Town & Country Planning Act 1990 (as amended)
Town and Country Planning (Development Management Procedure) (England) Order 2015
Application for approval of details reserved by conditions imposed on planning reference
BR/270/16/PL relating to condition no. 3 (Drainage), 4 (Arboricultural Protection Measures) & 6
(Materials & Finishes)
Villa Maria Campbell Road, Bognor Regis,

Arun District Council have decided to **REFUSE details reserved by condition for the following reasons:**

Project:-	Proposed Conversion Villa Maria Campbell Road Bognor Regis		
Title:-	Proposed Tree Works		
Client:-	SCG Properties Ltd		
Scale:-	1:100 (@A1)		
Drawn By:-	PJD	Checked By:-	
Date:-	18/07/17	Date:-	
Job.No:-	160035	Drg.No:-	24

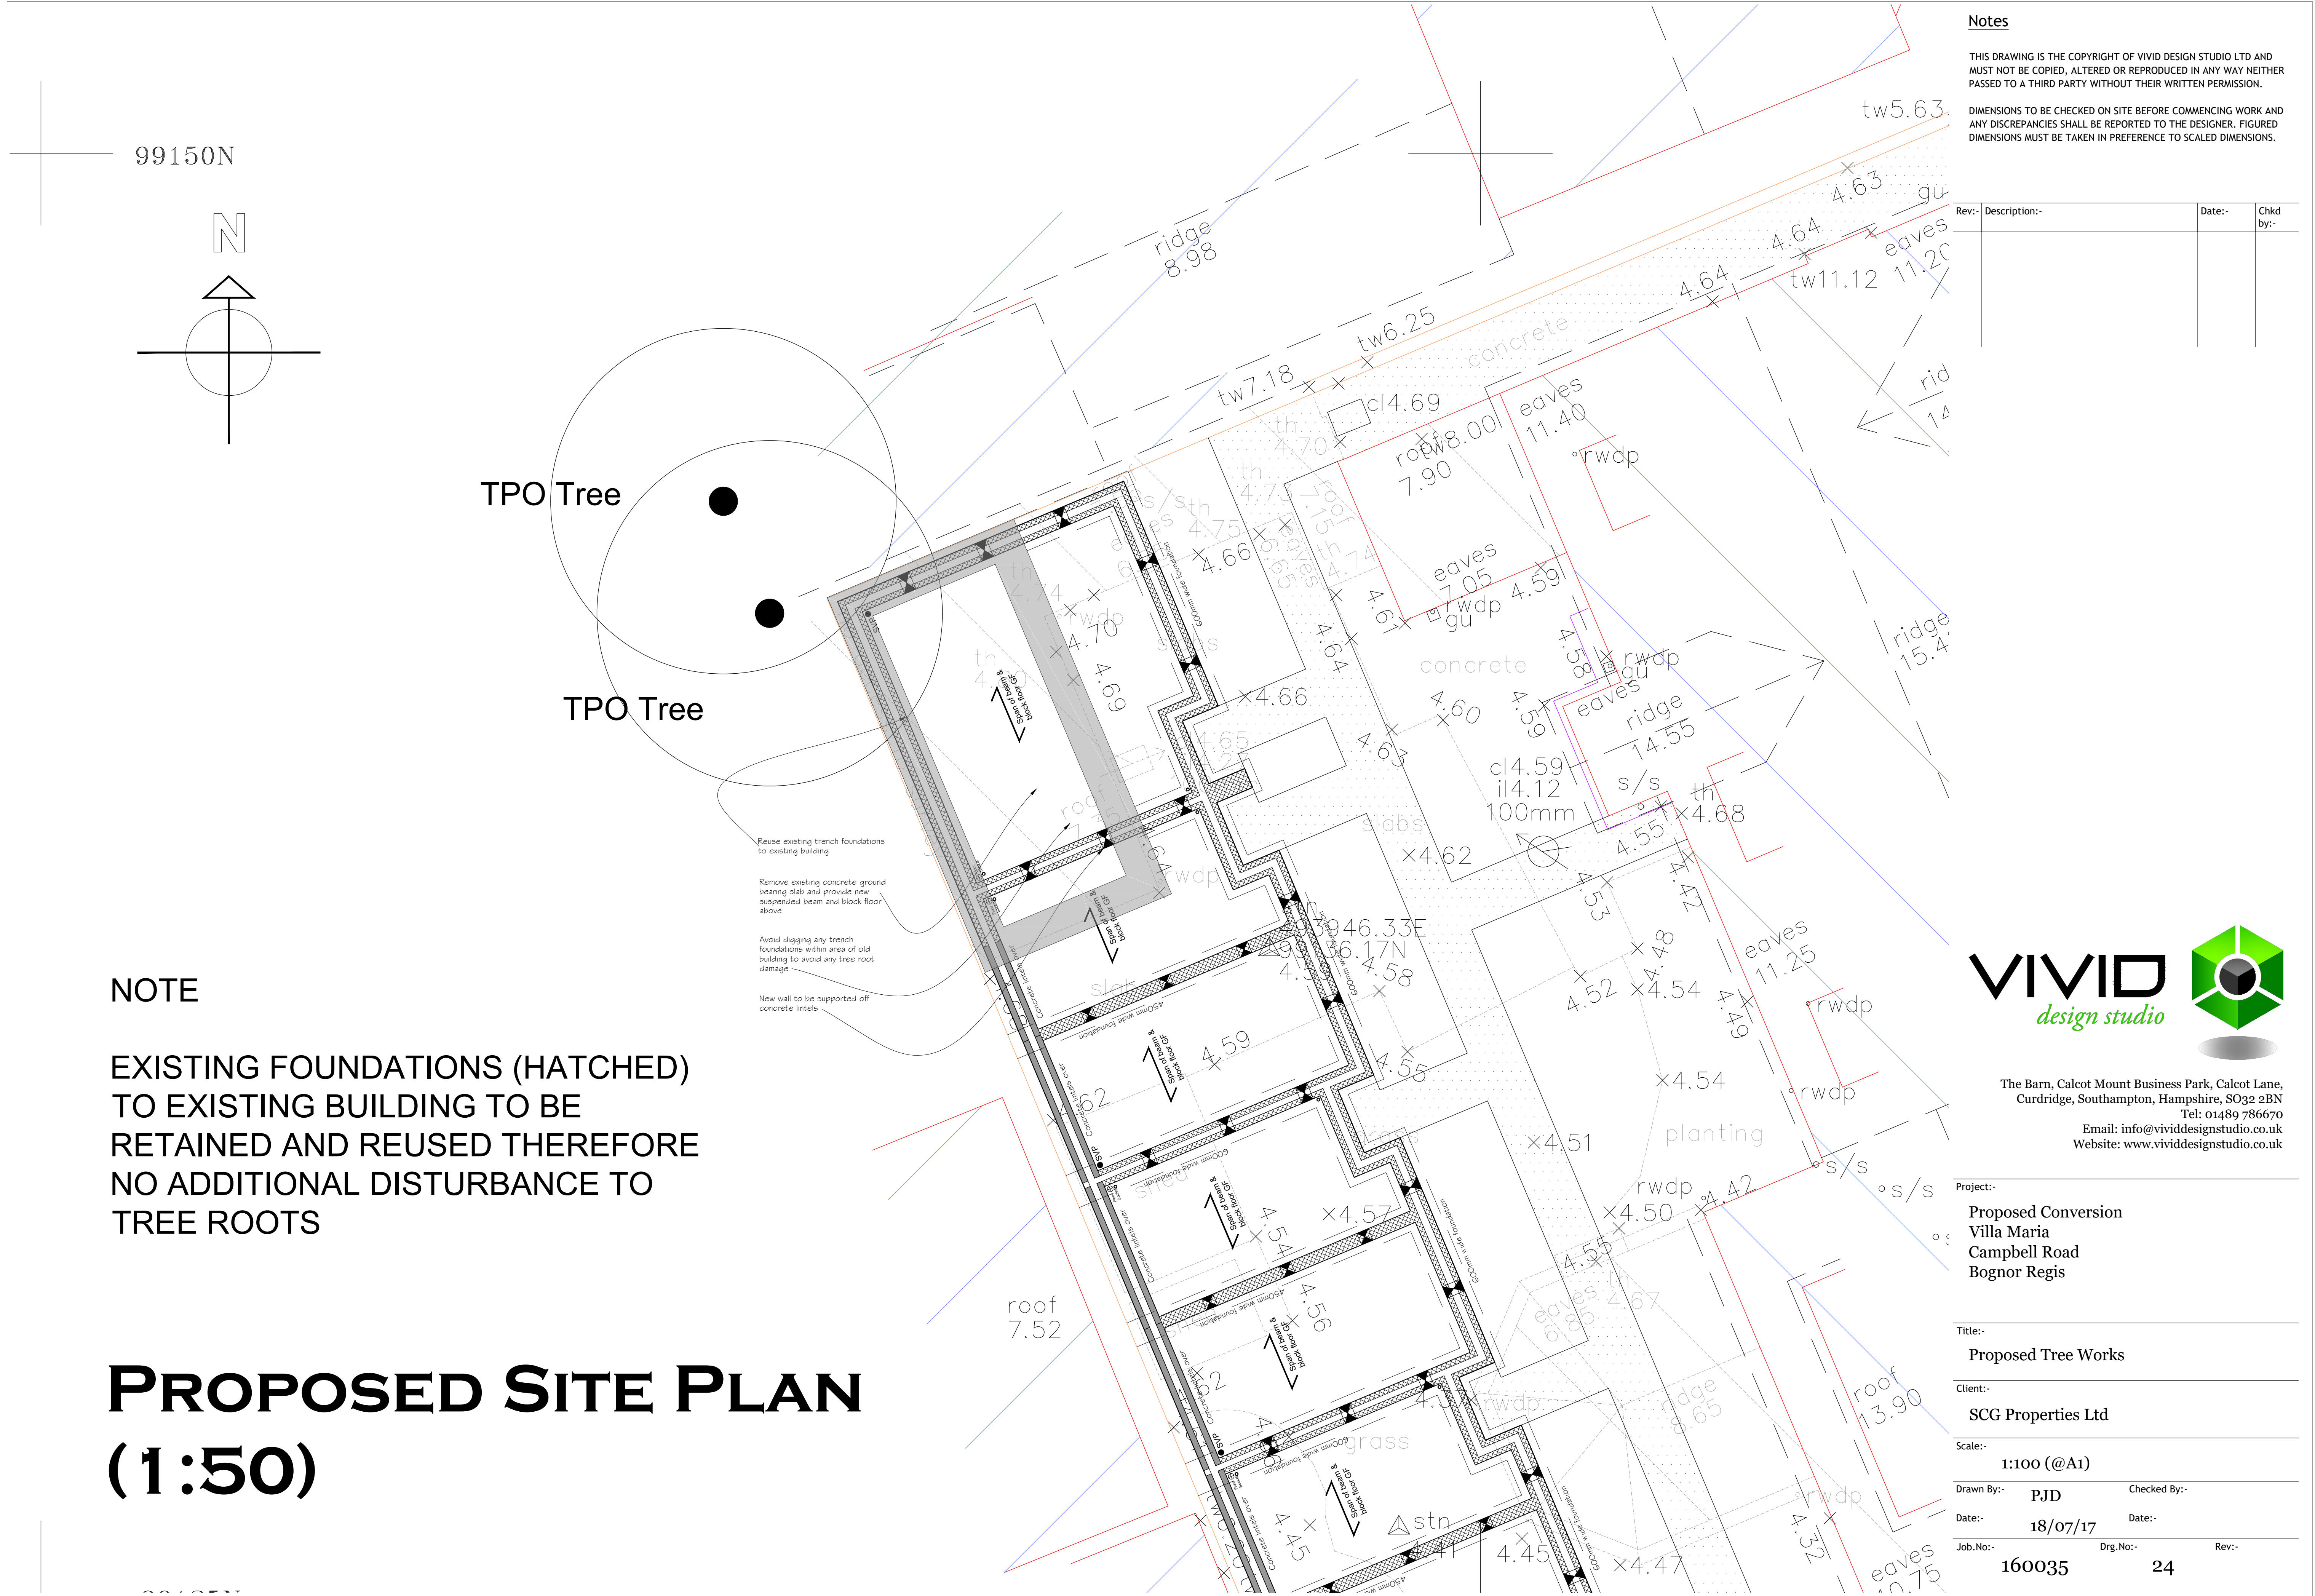
Our tree officer has assessed the scheme that has now been submitted but is not confident from the information submitted that work within the root protection area of the off-site protected trees was undertaken in a satisfactory manner.

On this basis, it is not possible to discharge the condition and I would recommend that prior to making a further application, you obtain informal agreement from our tree officer.
